10. **Project# 1005247**  
 11DRB-70297 VACATION OF PRIVATE EASEMENT  
 11DRB-70298 MINOR - PRELIMINARY/FINAL PLAT APPROVAL
- THE SURVEY OFFICE LLC agent(s) for BEN D COHEN TRUSTEE COHEN LIVING TRUST request(s) the above action(s) for all or a portion of Lot(s) 30-A & 30-B, Block(s) 10, **NORTH ALBUQUERQUE ACRES Unit(s) B**, zoned SU-2 M-1, located on OAKLAND BETWEEN SAN MATEO AND I-25 containing approximately .9995 acre(s). (C-18) **THE VACATION WAS APPROVED AS SHOWN ON EXHIBIT B IN THE PLANNING FILE PER SECTION 14-14-7-2(A) (1) AND (B) (1)(3) OF THE SUBDIVISION ORDINANCE. THE PRELIMINARY/FINAL PLAT WAS APPROVED WITH FINAL SIGN OFF DELEGATED TO TRANSPORTATION TO PROVIDE DIMENSIONAL EXHIBIT AND TO PLANNING TO ADD DRAINAGE EASEMENT.**

# DRB CASE ACTION LOG (PREL & FINAL)

Project # **1005247**

Project Name **NO ALBUQ ACRES, UNIT B**

SITE PLAN FOR SUBDIVISION
for
K-RAM OAKLAND FACILITIES

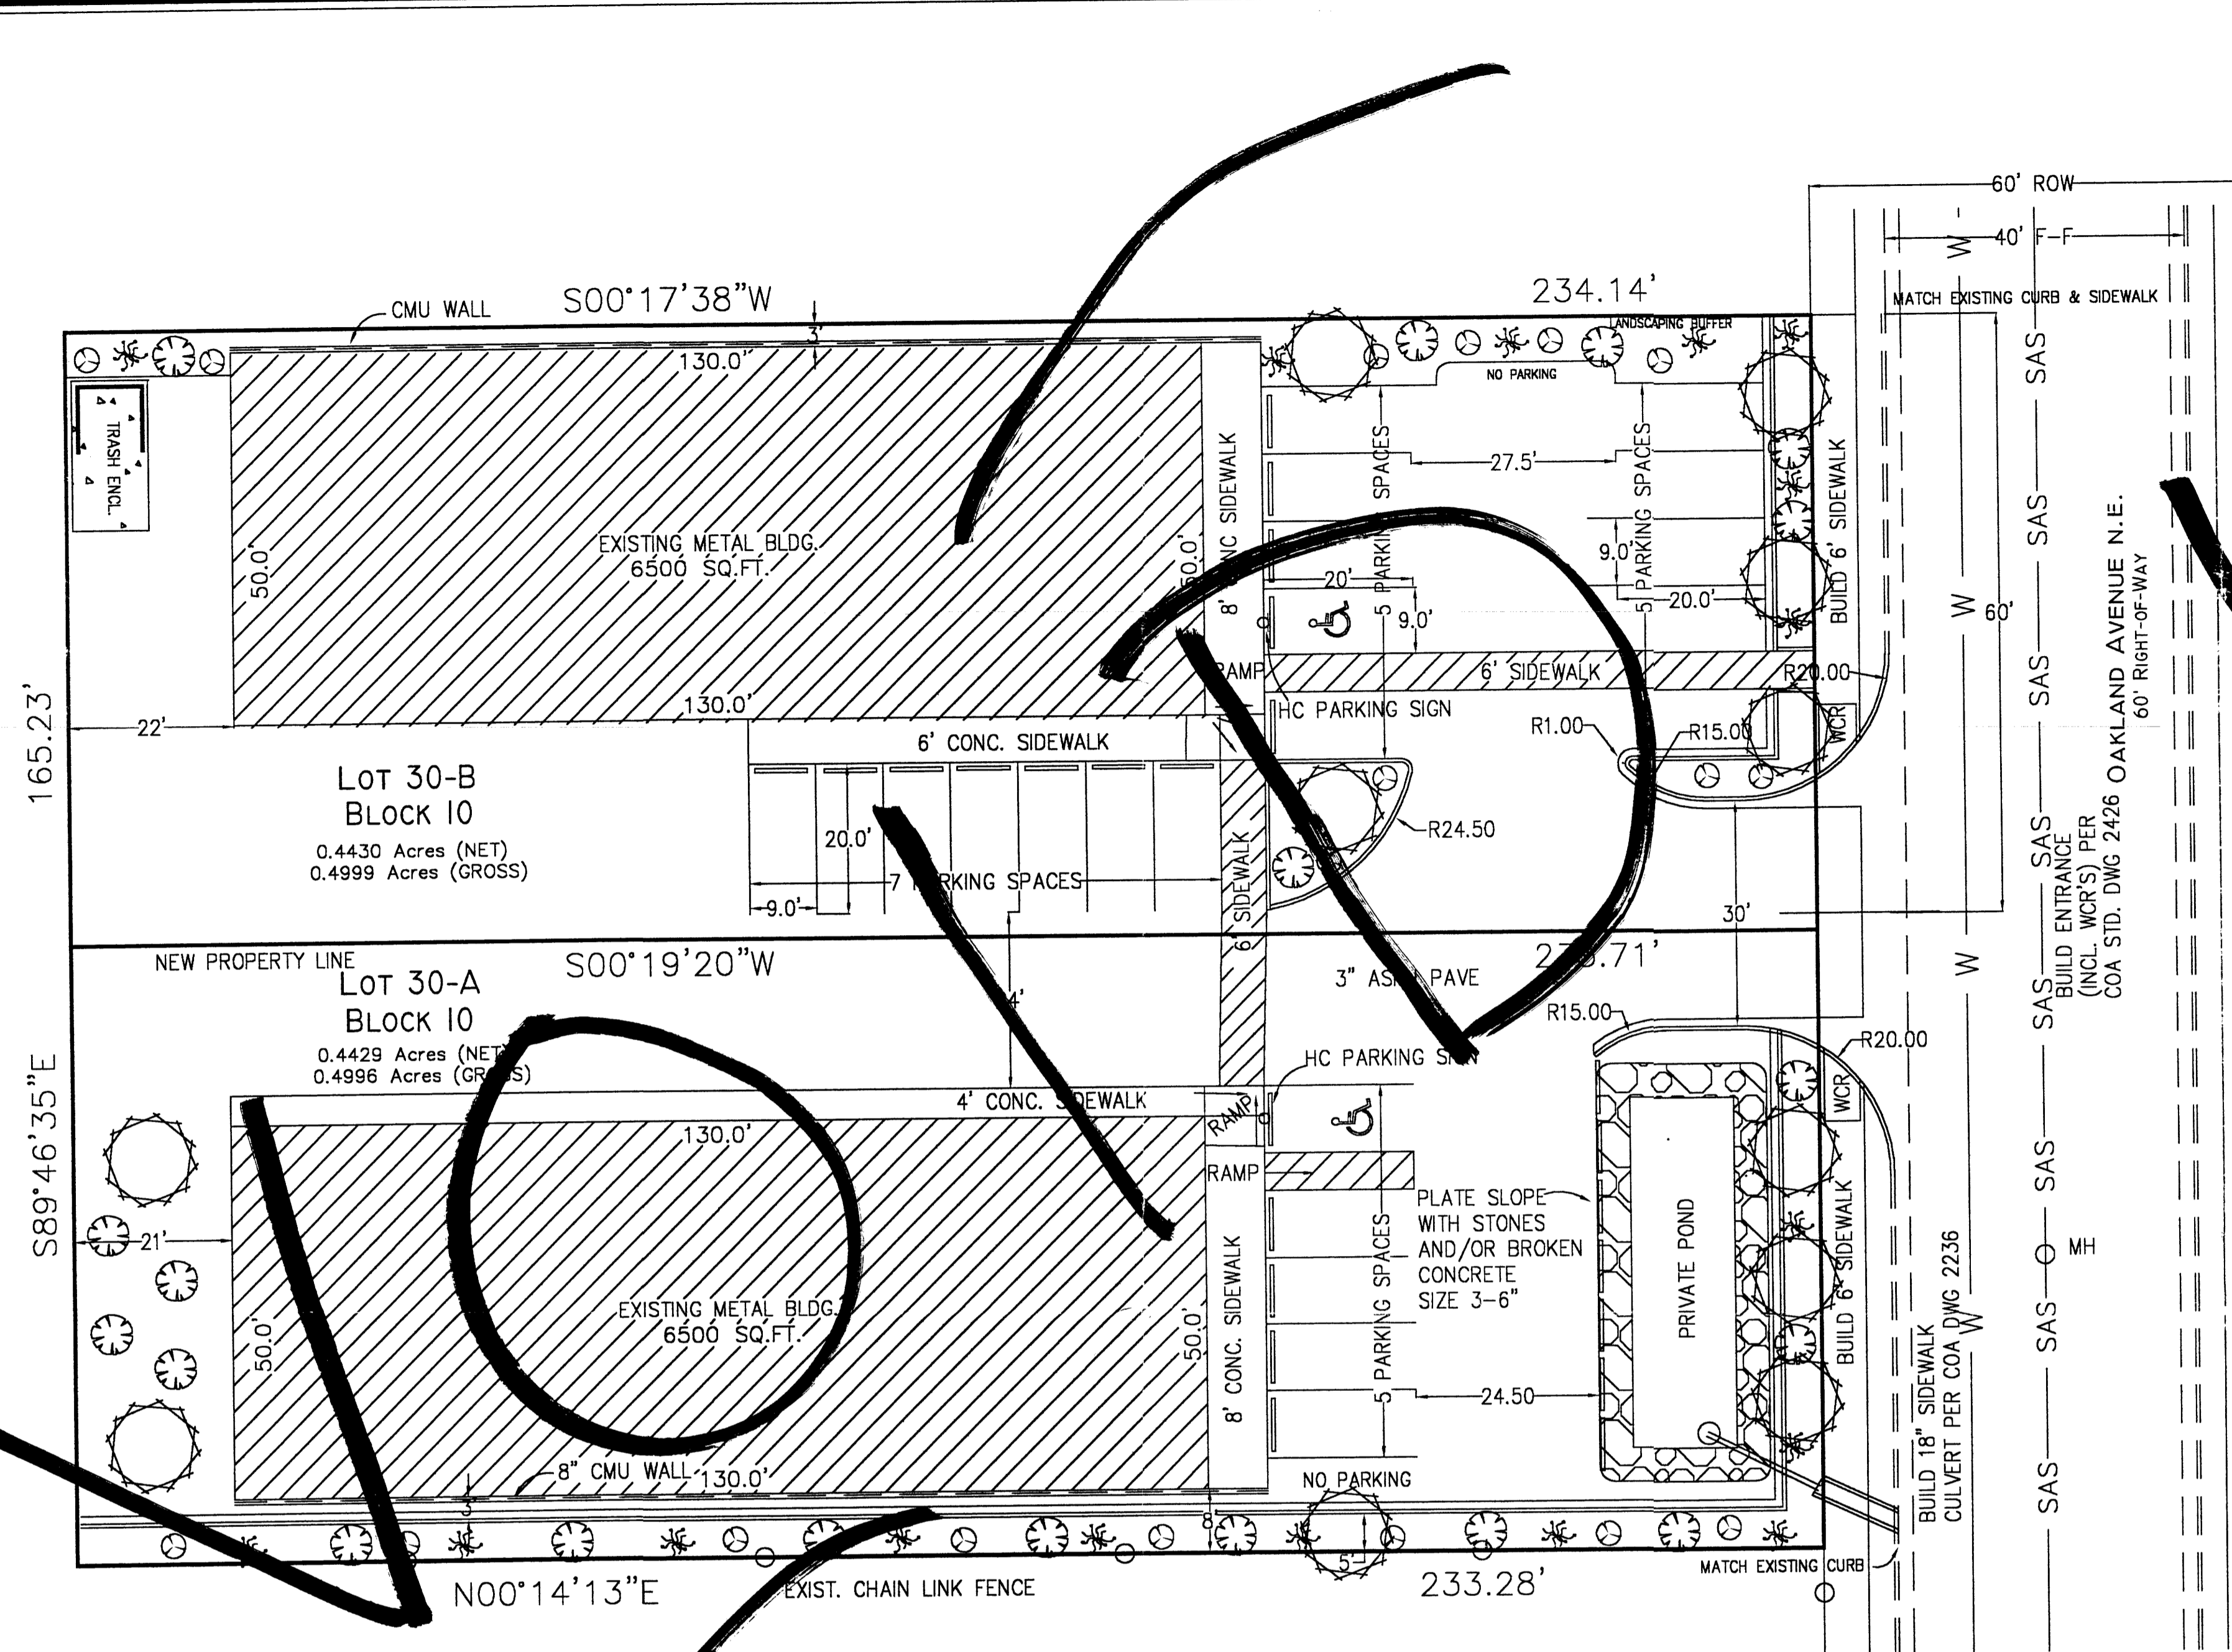
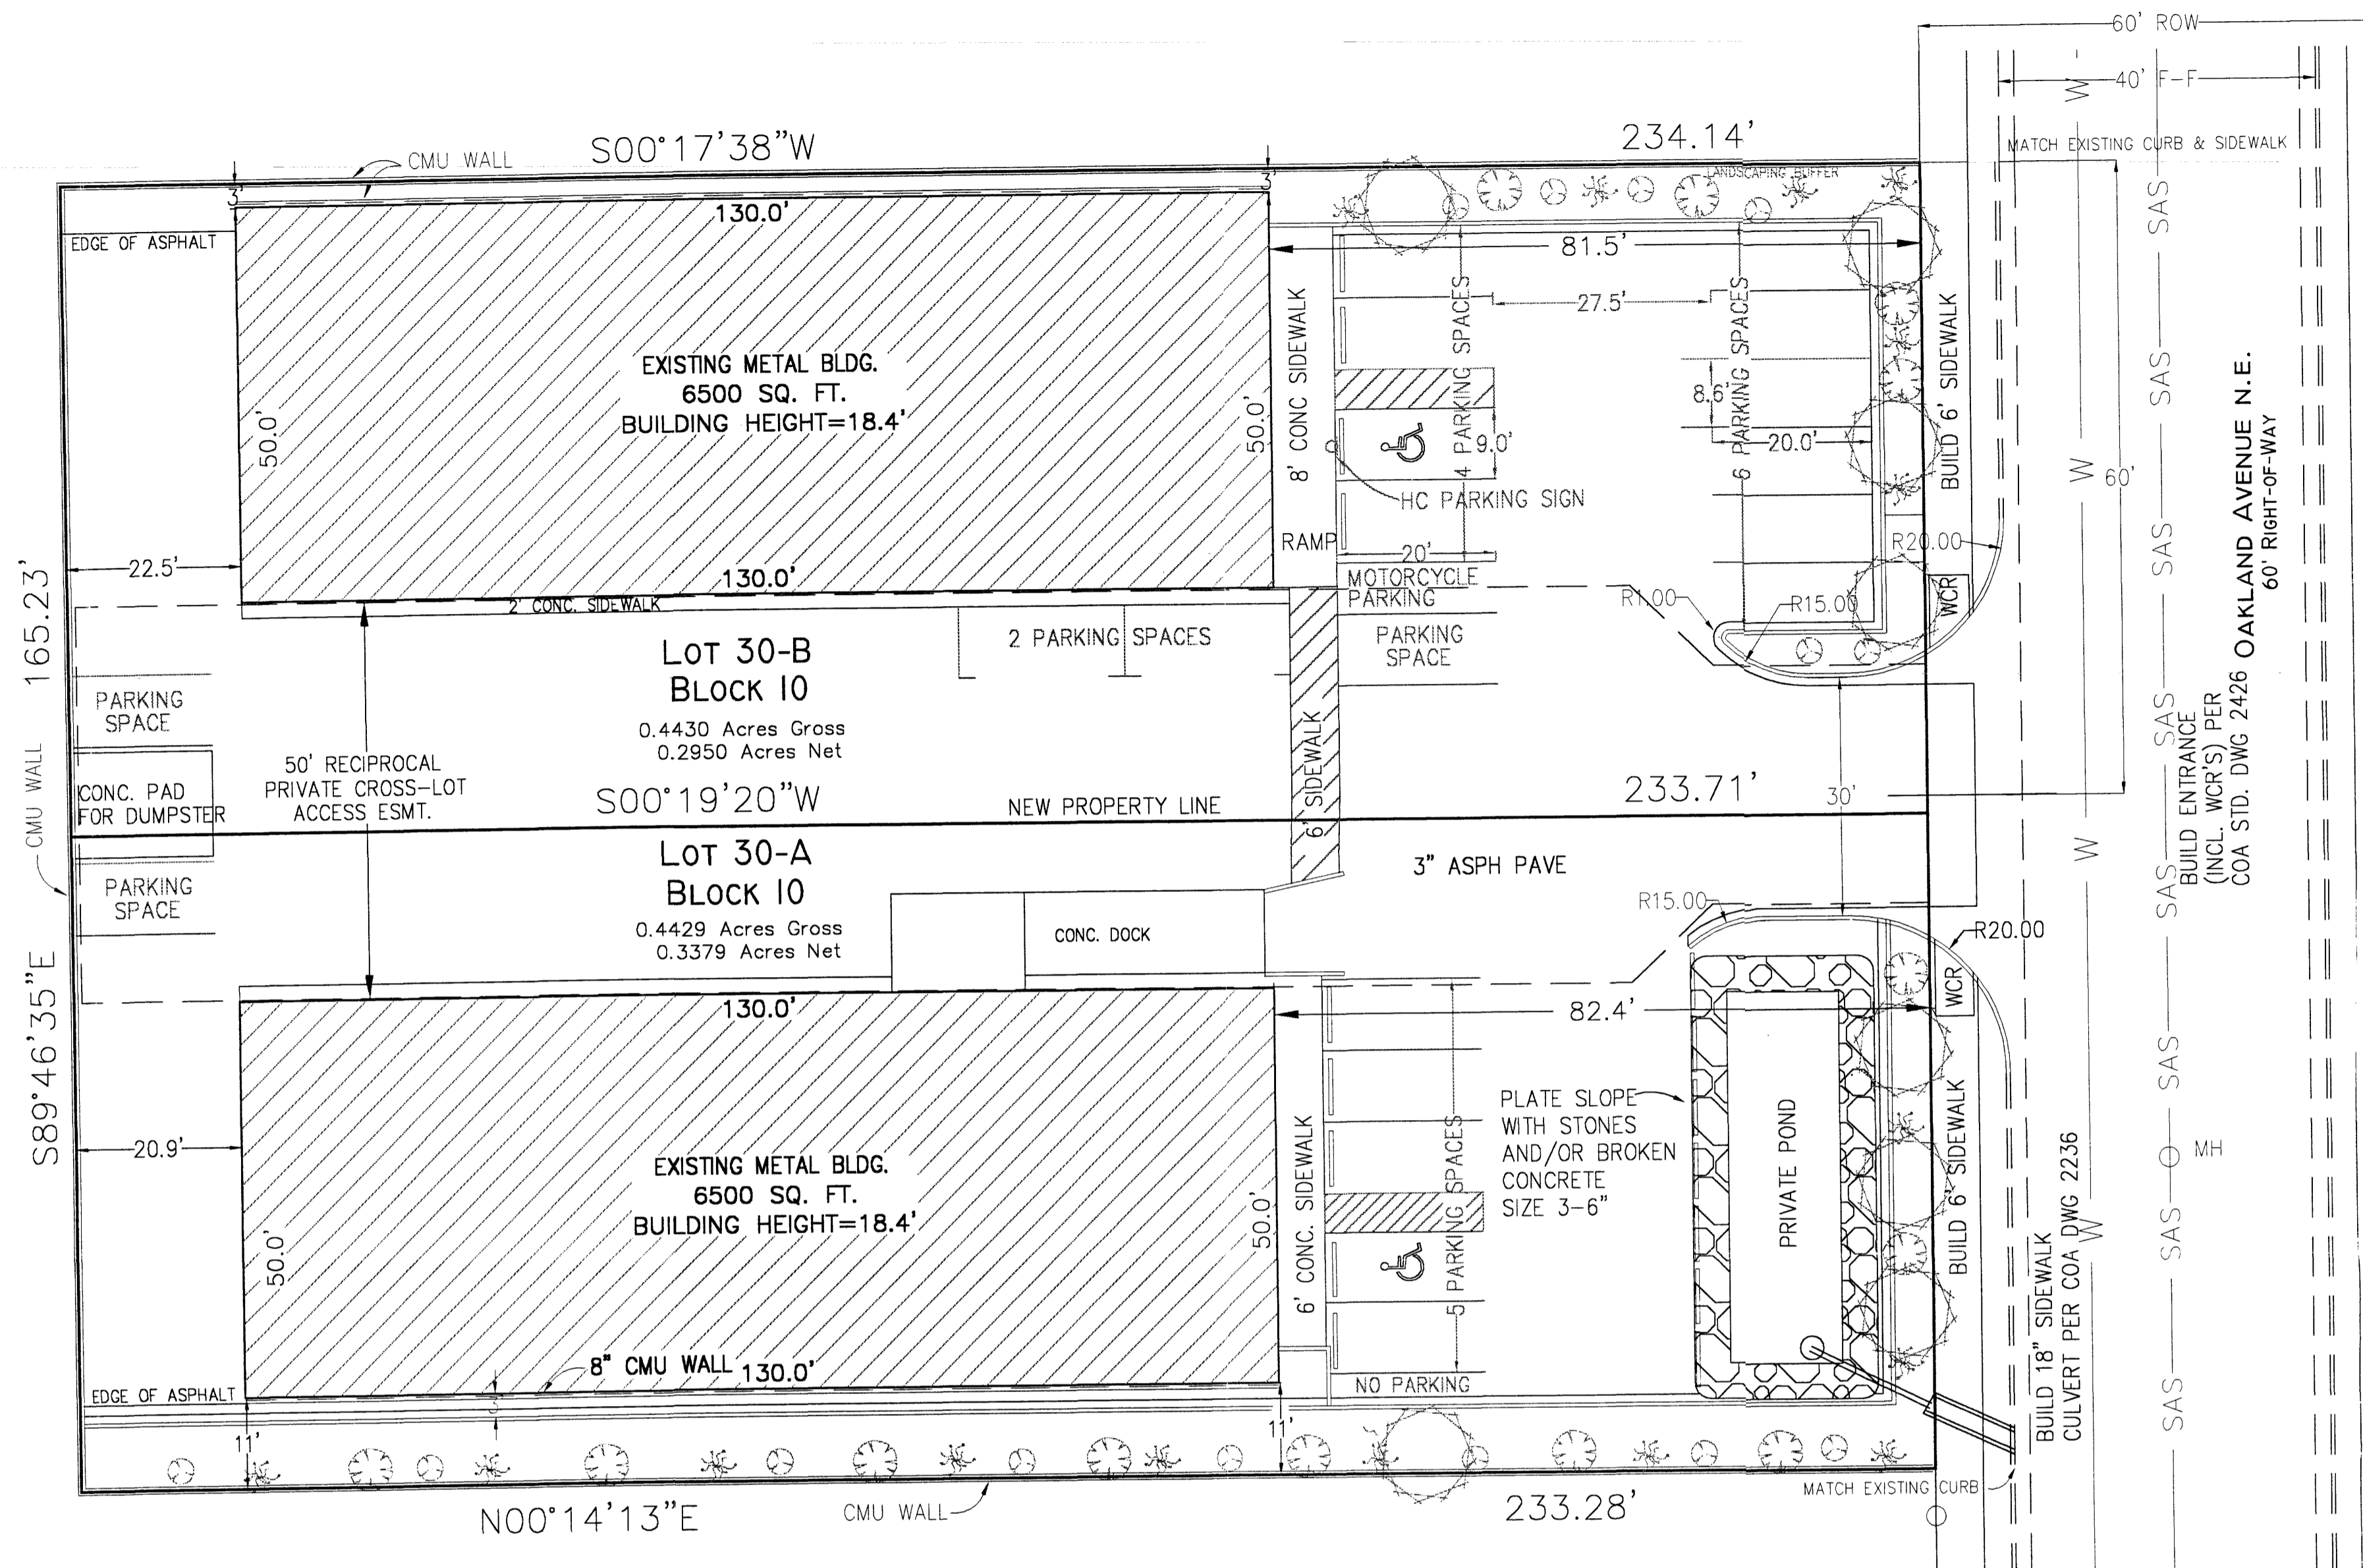
- TRANSPORTATION: DIMENSIONING OF STALLS
- PARKING BUMPERS
- ADA AND ACCESSIBLE STALLS
- SIDEWALK BUILD NOTE
- SIDEWALK CULVERT BUILD NOTE

located on OAKLAND AVE NE, between SAN MATEO BLVD NE and EAGLE AVE NE containing approximately 1 acre(s). [REF: 06DRB-01686, 06DRB-01605] (C-18) **THE SITE PLAN FOR SUBDIVISION WAS APPROVED WITH FINAL SIGN OFF DELEGATED TO TRANSPORTATION DEVELOPMENT FOR DIMENSIONING OF PARKING STALLS AND BUILDING NOTES ON THE SITE PLAN AND PLANNING FOR CHANGE OF TITLE TO READ 'SITE PLAN FOR SUBDIVISION' AND 3 COPIES OF THE PLAN.**
